## Wanda Sydney DA – Tower B Rooftop Bar Noise

We write responding to comments received on 24 February 2017 from City of Sydney Council (Letter ref. 2017/093556), relating to the acoustic assessment for Wanda Sydney.

Rooftop Bar

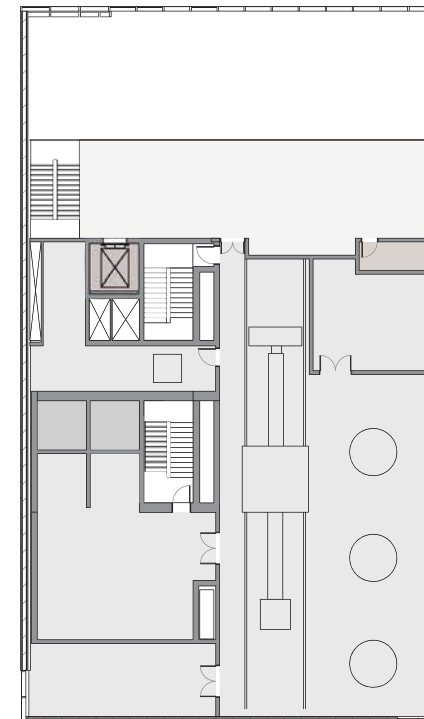
*The rooftop bar on level 24 (37 patrons) and level 25 (35 patrons) is expected to comply with noise requirements, however this is based on no background or amplified music. If music is proposed for this area an acoustic report should be submitted. Without this information, the terrace is likely to be subject to condition of consent prohibiting the use of speakers and outdoor music in this area.*

In response, we confirm that a full acoustic assessment of the rooftop bar was included in report "Acoustic Assessment for Entertainment Noise of Wanda Sydney Tower B", submitted with the application, and is set out in Section 4.2 Entertainment Noise Break-out. The acoustic assessment report presented the following:

The retractable roof has been designed to be a solid roof system with acoustic seal; thus the outdoor bar area will be enclosed when the retractable roof is extended (i.e. cover the outdoor area). It is anticipated to provide adequate noise reduction to enable amplified music in the outdoor area. In addition, adjustments/control of amplified music volume

It has been confirmed that the retractable roof system has been included in the DA architectural drawings and therefore amplified music should not be prohibited in the area.
